**From:** dc.support@cherwell-dc.gov.uk  
**Sent:** 25 April 2022 17:00  
**To:** DC Support  
**Subject:** New comments for application 22/00959/REM

New comments have been received for application 22/00959/REM at site address: OS Parcel 9100 Adjoining And East Of Last House Adjoining And North Of Berry Hill Road Adderbury

BERRY HILL ROAD, ADDERBURY - EATON V2 ELEVATIONS

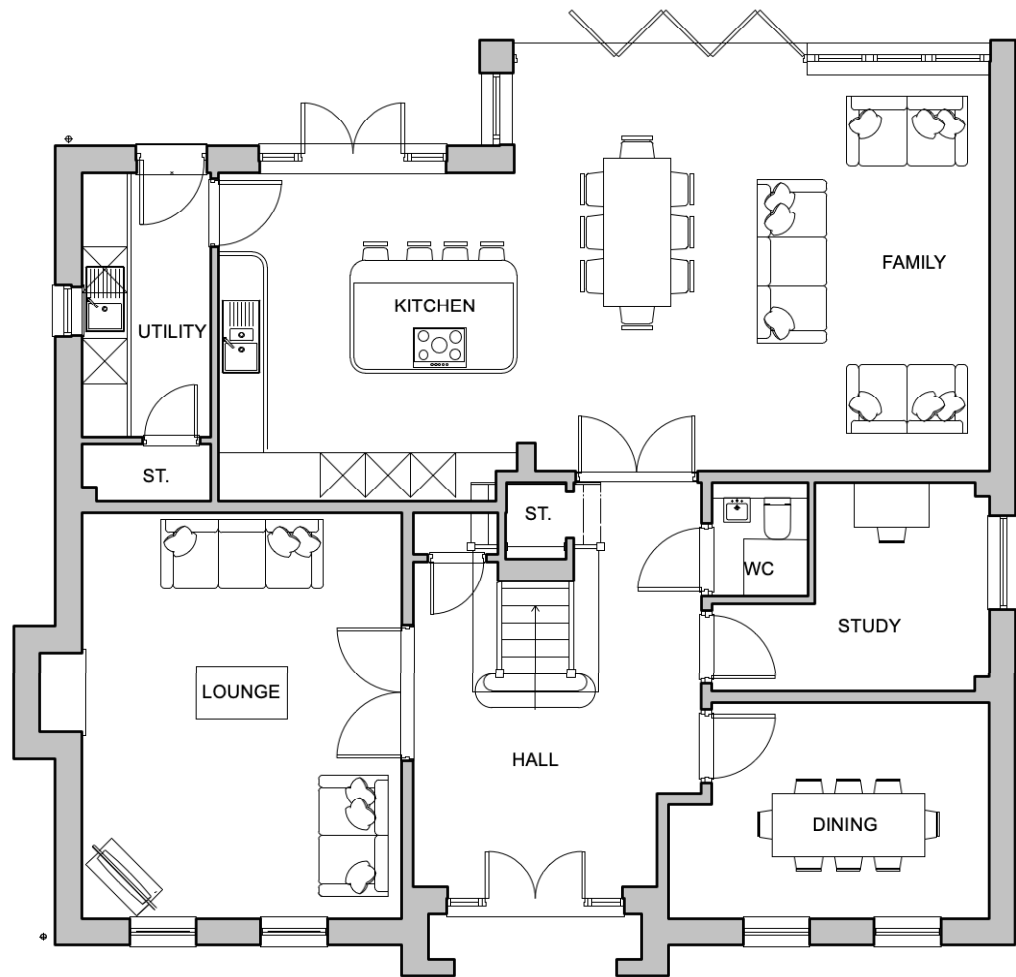
2. The dwelling, EATN V2 and garage, will probably obstruct the line of site from our back garden to Adderbury Church, currently an unobstructed view. Can you confirm the relative elevation of EATN V2 once built, as the ground does slope away from the level of the Shaldon garden. If it does obstruct our view, would it be possible to re-design the plan so that this dwelling is relocated in the direction of EATN V1?
